## **Development Facilitation Team (DFT) – Review Comments**

**DRB Project No: PR-2023-008250 Date: 03/01/2023 Agenda Item: #2 Zone Atlas Page: B-15**

**REQUEST:** SITE PLAN ADMIN – DFT: Glass-Rite New Office/Warehouse: 5605 Venice Ave. NE

**Project Name:** Glass-Rite New Office/Warehouse: 5605 Venice Ave. NE

SDP-2

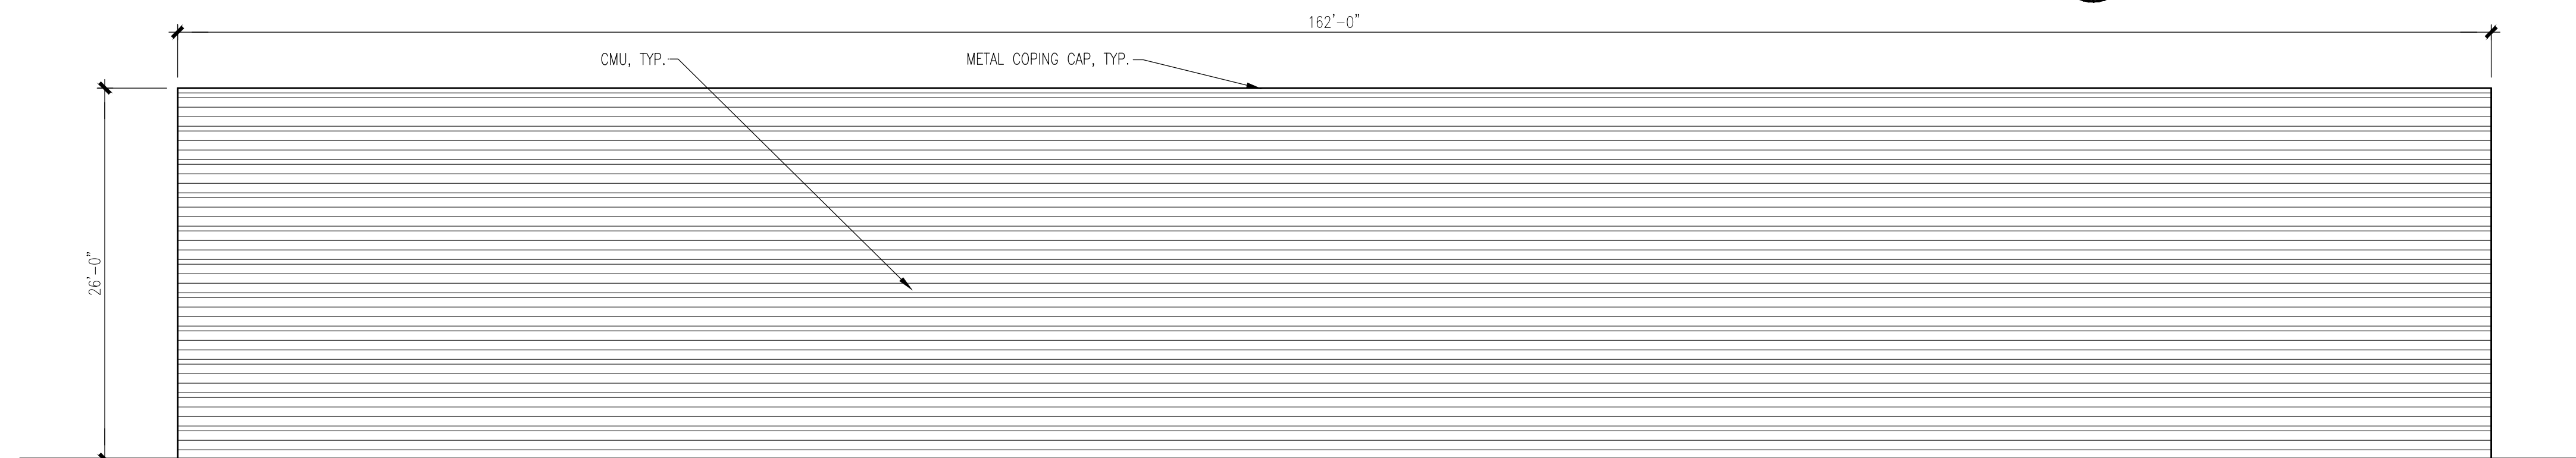
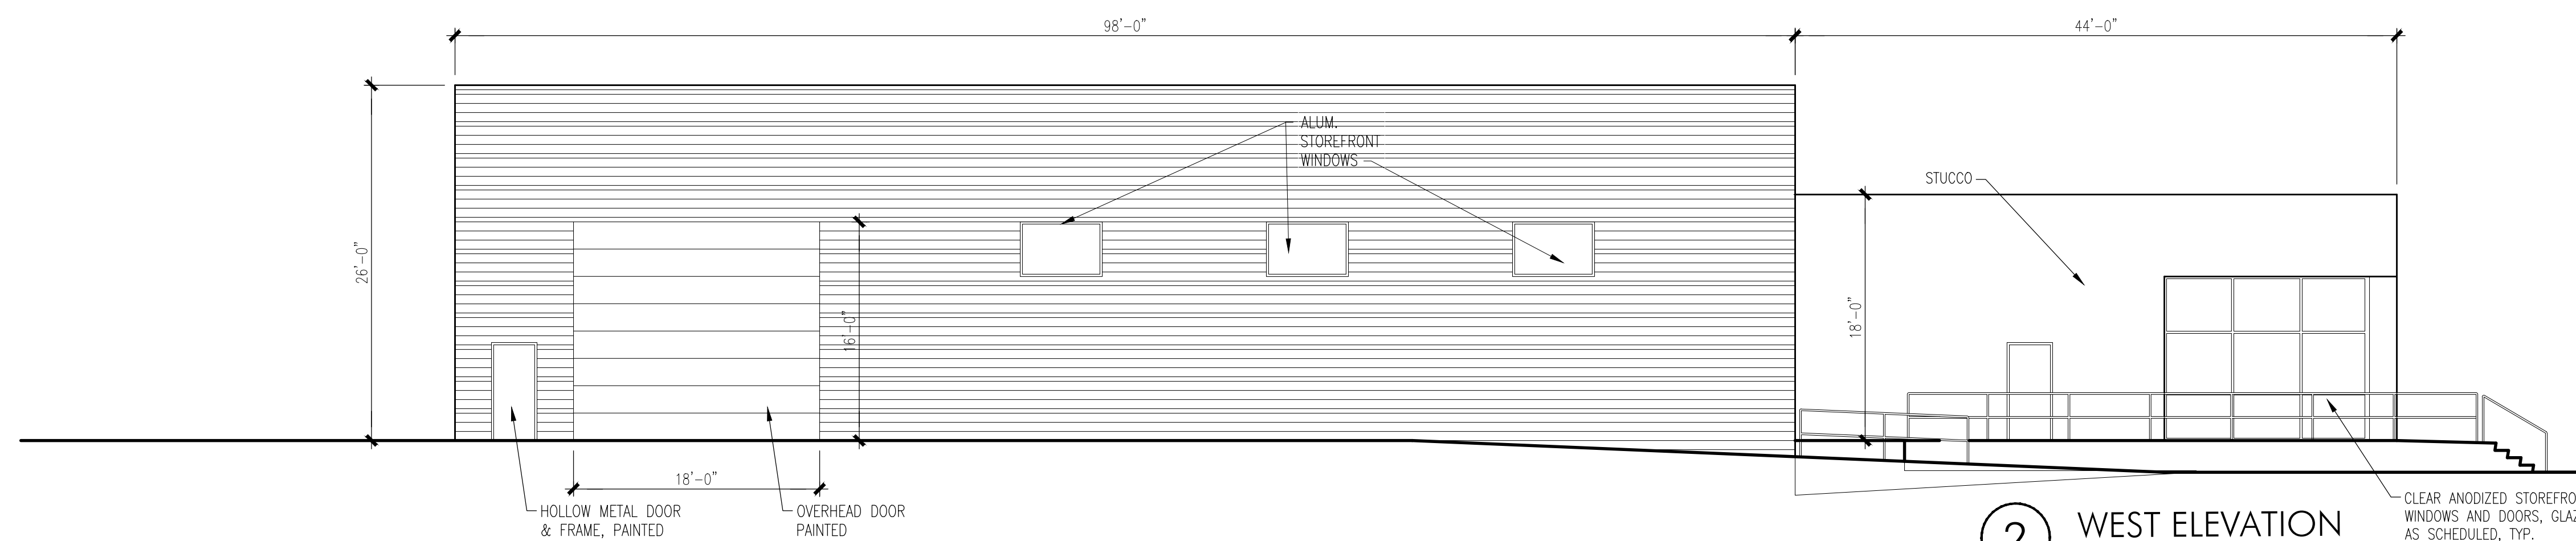
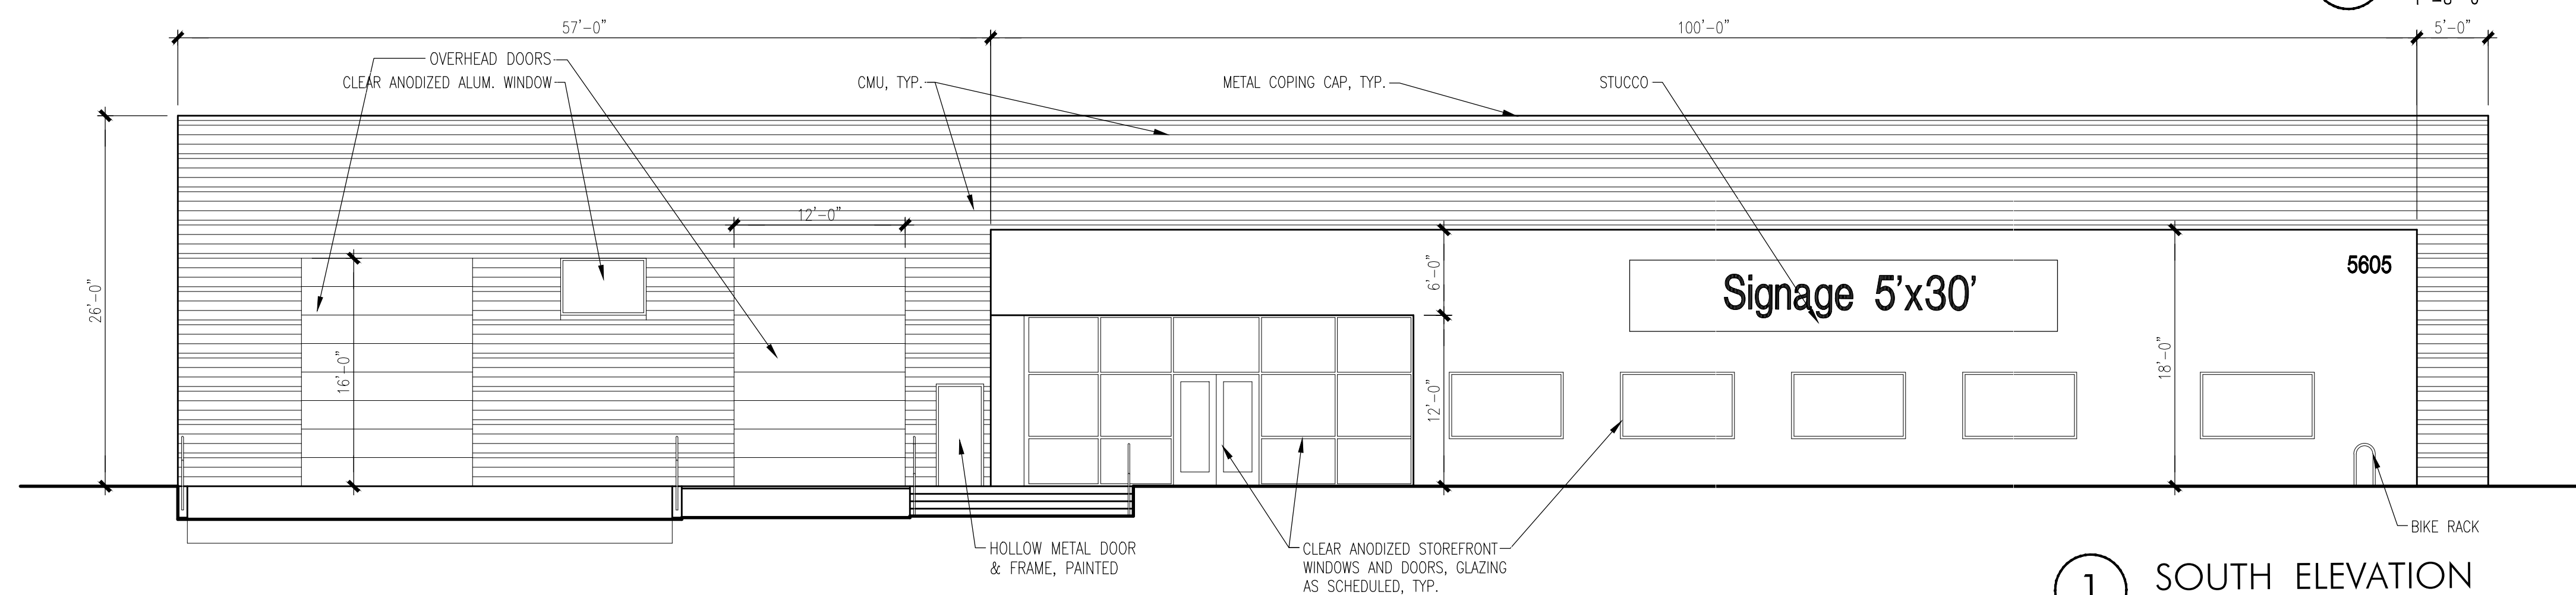
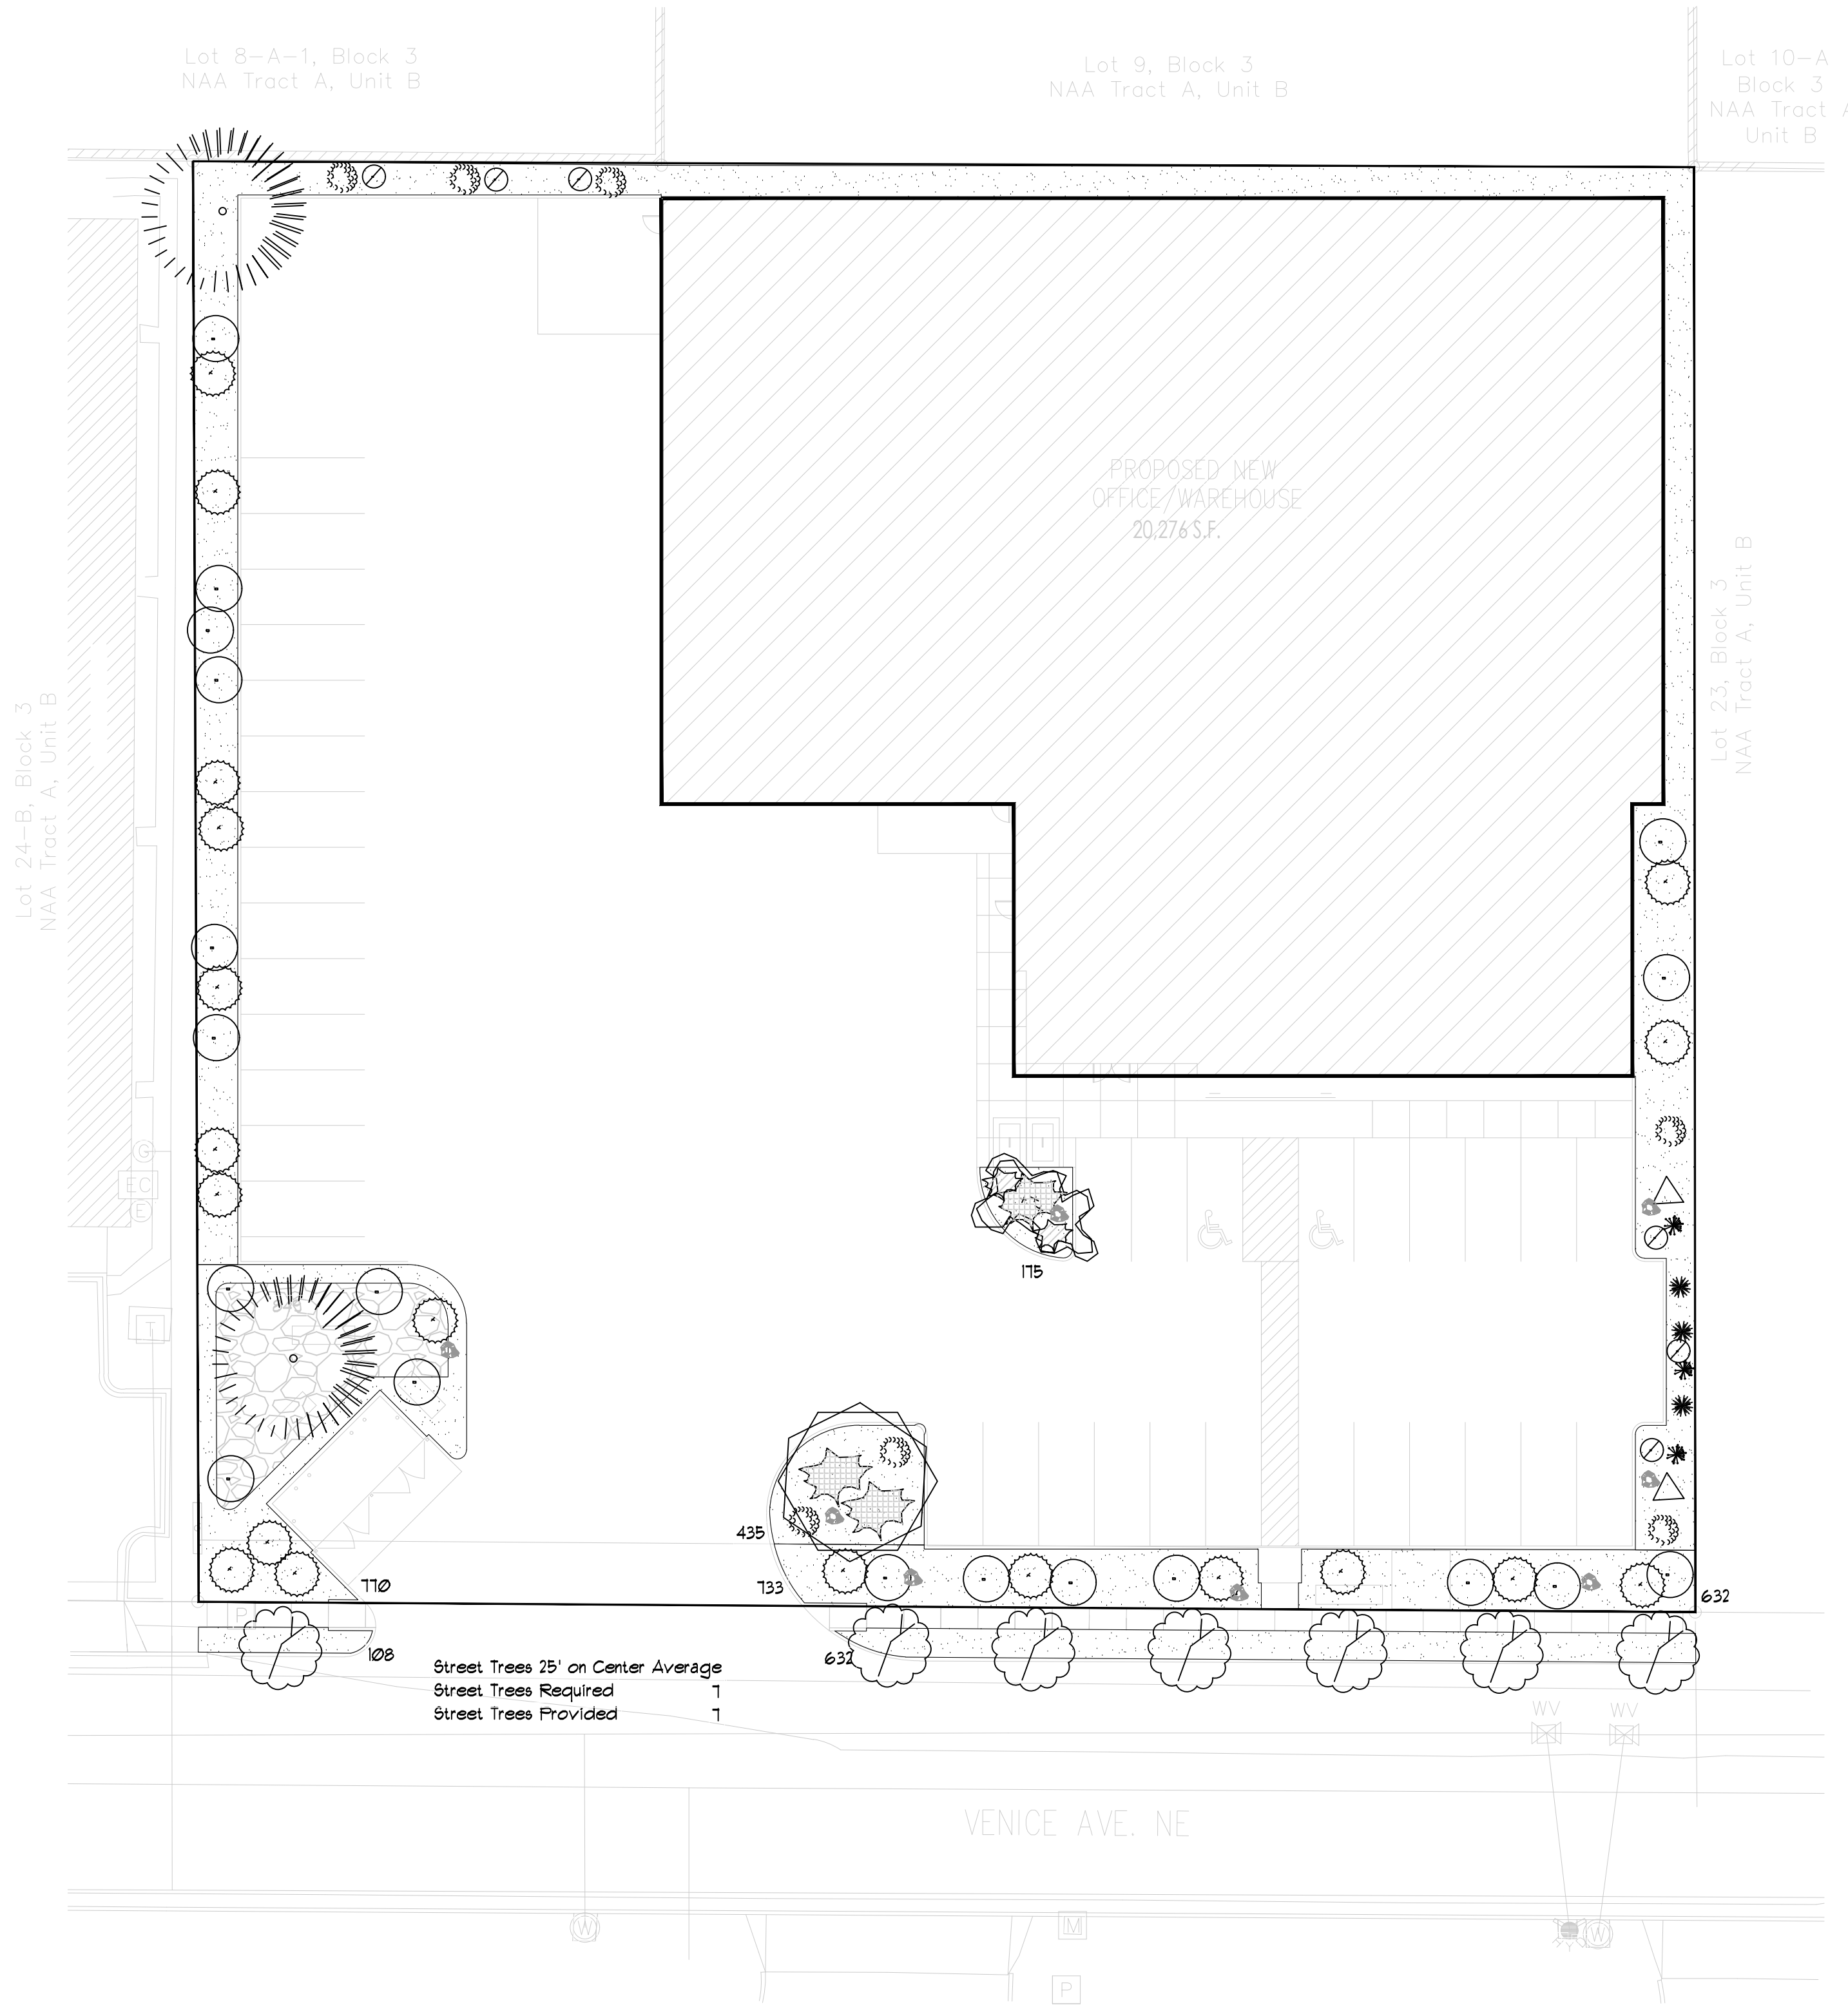
- a) Show light reflective values (LRV) range from 20-50%, as per IDO 3-4(K)(4)(b)(3).
  - b) Show how building facades meet requirements of IDO 5-11(E), as required by IDO 3-4(K)(4)(b)(1).

**\*This site is located within Sub-Area 3 of the North I-25 – Character Protection Overlay Zone. Per 3-4(K)(4)(b), the following façade requirements must be met, and the applicant must confirm how these requirements are being met as notes and/or depictions on the Site Plan and additionally (as an option) in a comment response letter:**

- The Building Design standards of 5-11(E) of the IDO must be met.
- Primary building façades that face a public street shall wrap around the building at a distance of 1/3 the depth of the building or 20 feet, whichever is greater.
- Building materials and colors shall have a light reflective value (LRV) ranging from 20 percent to 50 percent.
- Reflective or mirrored glass is prohibited.
